**SOIL/SITE EVALUATION
 for ON-SITE WASTEWATER SYSTEM**

Owner: 06-500 14921

06-500 14925
 Lot 165
 Yorkshire Plantation

LOT # 165 YORKSHIRE PLANTATION
SCALE: 1"-40'

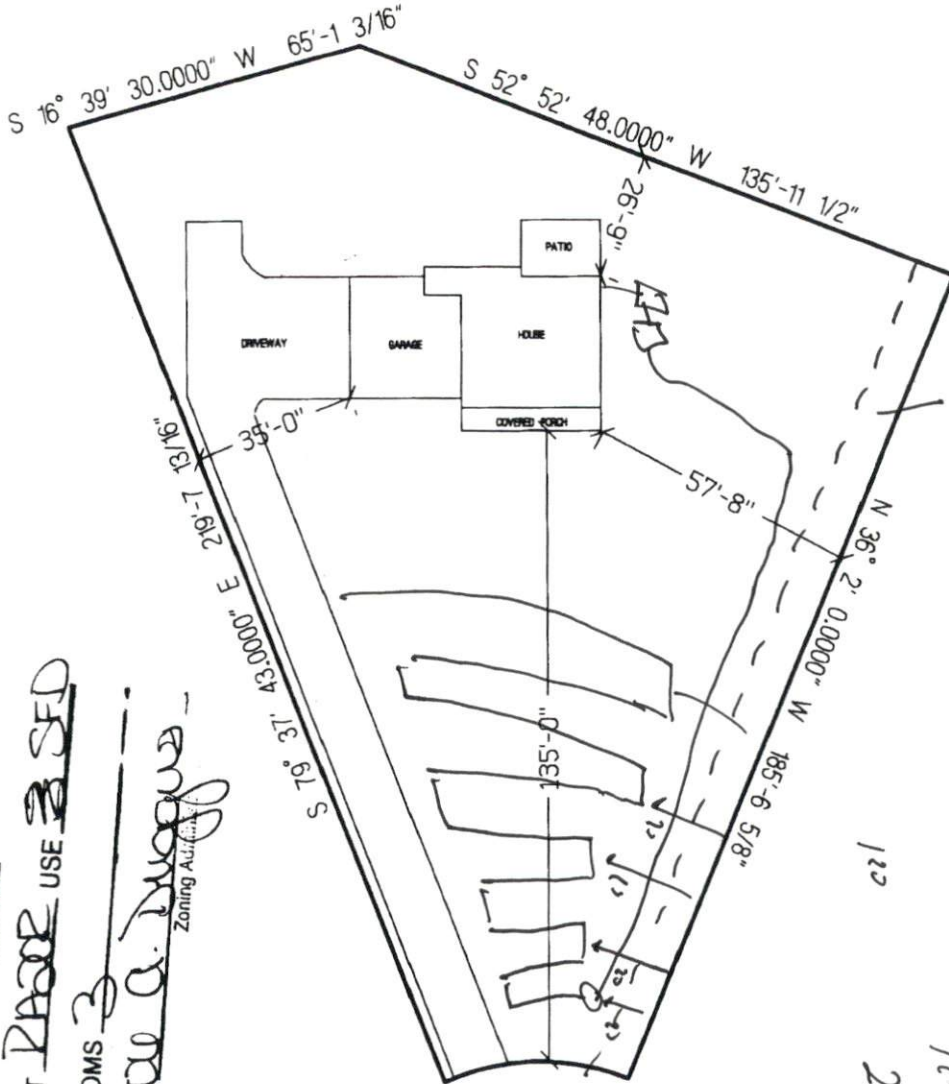
Must move house back, beyond shown set backs
 Driveway must be along property line with easement along it
 Drive to be a max. of 10' wide
